North Yorkshire Council

Landscape Mitigation Proposals

**Helios Renewable Energy
Project**

EN010140

Environmental Statement Figure 7.19: Landscape Strategy Plan (Overall)

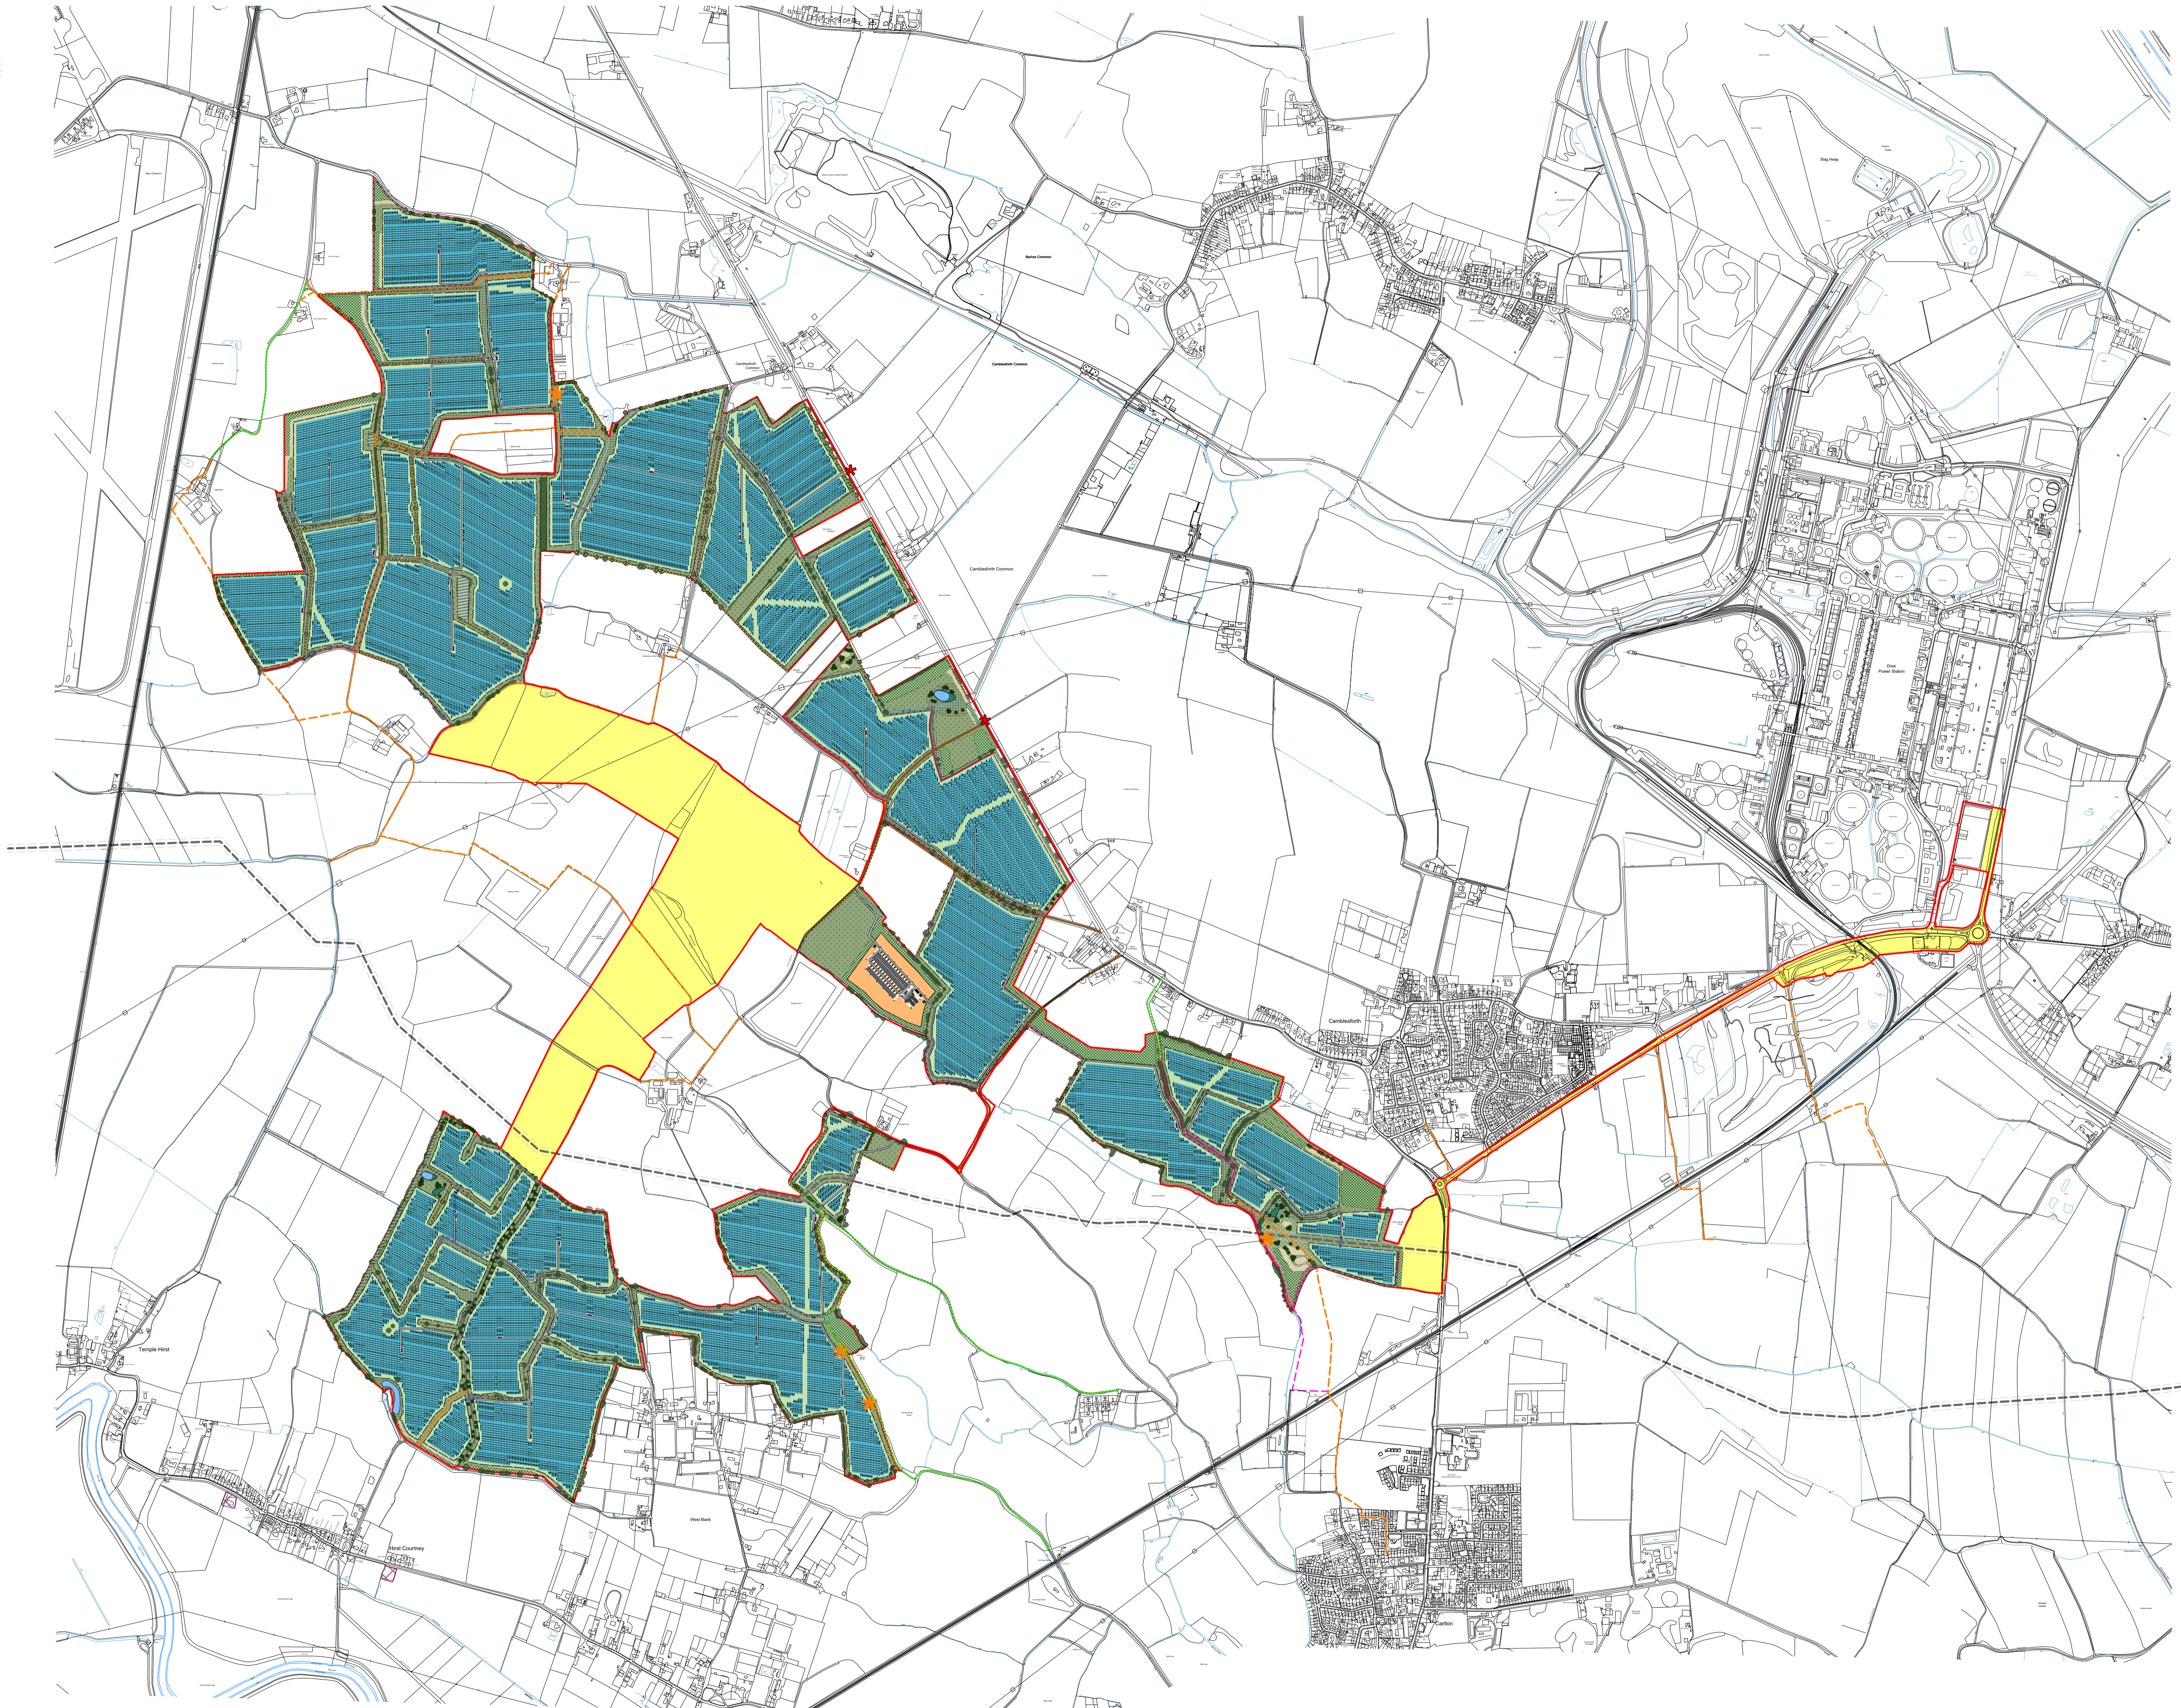
- 2.3 Although we would generally support the positive improvements made to the Landscape Strategy Plan and Illustrative Landscape Masterplan and outline Landscape Ecological Management Plan (oLEMP), these positive effects are not outweighed by the negative and significant cumulative impacts that will arise given the overall size and scale of the proposed development and in combination with other major developments including NSIPs in the study area, as listed in the assessment of Cumulative Effects [APP-035, Table 15.1] and topic chapter of the ES [APP-027, Table 7.8 and Table 7.9].

6.4 There is no evidence of use or reference to these Standards in the Applicant's submissions. The Applicant's Landscape Strategy [APP-088] and Illustrative Landscape Masterplan [APP-0393] focus only on landscape mitigation within the application red line boundary.
